Date: 10 January 2025
Our ref: Case: 27347 Consultation: 497793
Your ref: EN010115

Application by Five Estuaries Offshore Wind Farm Limited for an order granting development consent for the Five Estuaries Offshore Wind Farm project

Request for Further information – Benthic Ecology

**Figure 5 Maximum length of cable in SAC**

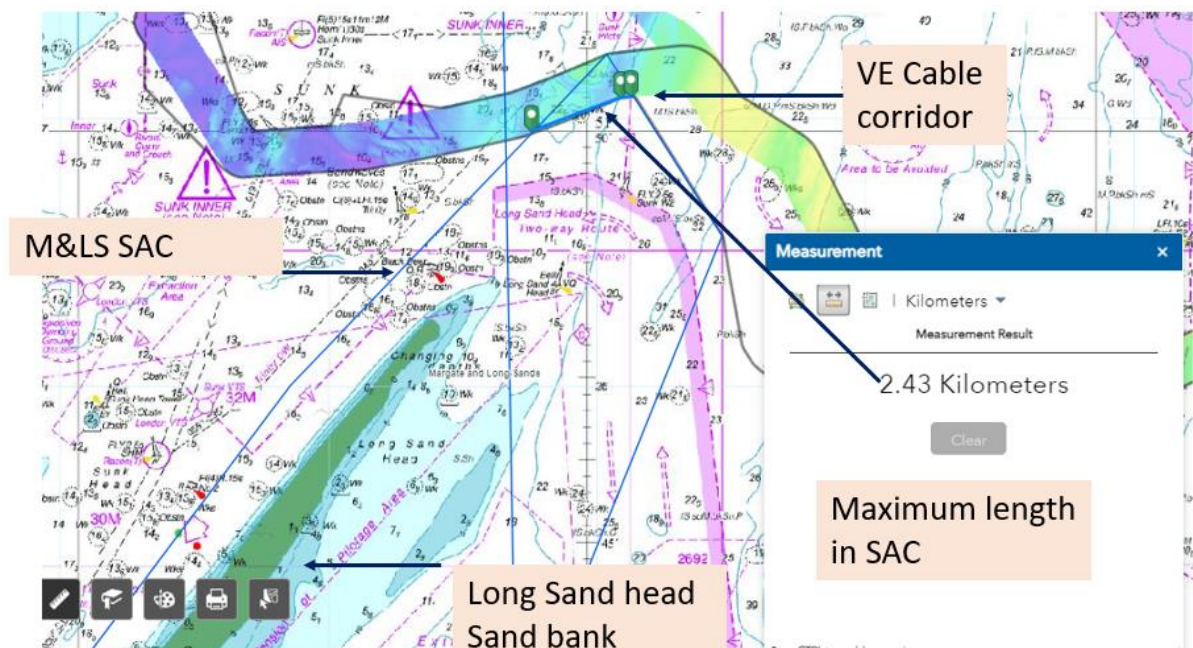
NE Ref	Summary of Key Concerns	Natural England's Recommendations to Resolve Issues.	Question from the ExA: Has the submission of [REP4-034] addressed your concerns? If not, explain why that is the case
E1	<u>Insufficient evidence</u> Natural England is concerned that the methods and information used to determine maximum length of cable protection within Margate and Long Sands Special Area of Conservation (MLS SAC) are not transparent and appear to be high level, and as such, it is not clear how realistic this Maximum Design Scenario (MDS) is. Natural England advises that due to	Natural England advises that further information is required to provide the necessary confidence in the MDS/Worst Case Scenario (WCS) for cable protection within the SAC.	Whilst Natural England welcomes the Applicant's updated Technical Note – Methodology for Determining MDS (Offshore) Rev B [REP4-034], we advise that the MDS/WCS for cable protection within the SAC remains unclear across all relevant documents.

Natural England's Relevant and Written Representations	NE Ref	Section Ref	Comment	Recommendation	Question from the ExA: <i>Has the submission of [REP4-034] addressed your concerns? If not, explain why that is the case</i>
Natural England's Position on Worst Case Scenario or Scenarios	E7	APP-242 9.12 & APP-239 9.9	<p>It is not clear to Natural England what information has been used to determine the maximum length of cable protection required within MLS SAC (i.e. 900 m). It is also not clear whether the potential for the addition of further cable protection has been considered and included within the calculations for MDS/WCS for scour protection within the SAC.</p> <p>These documents are written from an engineering perspective rather than from an ecological one trying to understand the impacts from sub optimally buried cables and potential impacts to designated sites.</p>	In order that a meaningful assessment can be made, Natural England require the applicant to provide a transparent justification for the WCS quantification of benthic impacts within MLS SAC, drawing upon previous experience and available information about the ground type along the ECC route. The WCS should also include any possible post-construction measures such as the placement of additional scour replenishment.	No, Natural England concerns have not been addressed. The updated Technical Note ' <i>Methodology for Determining MDS [REP4-034]</i> ' does not clearly state either the total area, or volume of cable protection required within Margate and Long Sands SAC for both cables. Natural England reiterates that whilst these calculations continue to be ambiguously stated within the Applicant's documents, it is not clear how the regulator will be certain that the WCS within the SAC has not been exceeded.

<p>Natural England would welcome additional information relating to the WCS volume of cable protection (as well as the total cable length) within Margate and Long Sands SAC so that it is clear to all parties what the thresholds are. Natural England queries how the regulator will be certain that the WCS within the SAC has not been exceeded? If the Secretary of State (SOS) is minded to consent the project, further DCO/dML restrictions may be appropriate.</p>	<p>For example, whilst an area of 5,400 m³ has been stated within the Technical note (Section 3.1.5 and 3.3.2), it is not clear that this figure refers to only one of two cables thus the estimated WCS is double the 5,400 m³. In addition, volume calculations remain absent from the updated Technical Note. Therefore, we advise that all relevant documents will need to be updated to clearly demonstrate the <u>total area and volume</u> of cable protection required within the SACt. And whether that will be one linear line of protection or multiple of a particular length and design.</p> <p>Natural England notes that the technical note [REP4-034] appears to deal with cable installation only and does not cover operation. Our outstanding concern raised in our Relevant Representations A15 [PD2-003] regarding the</p>
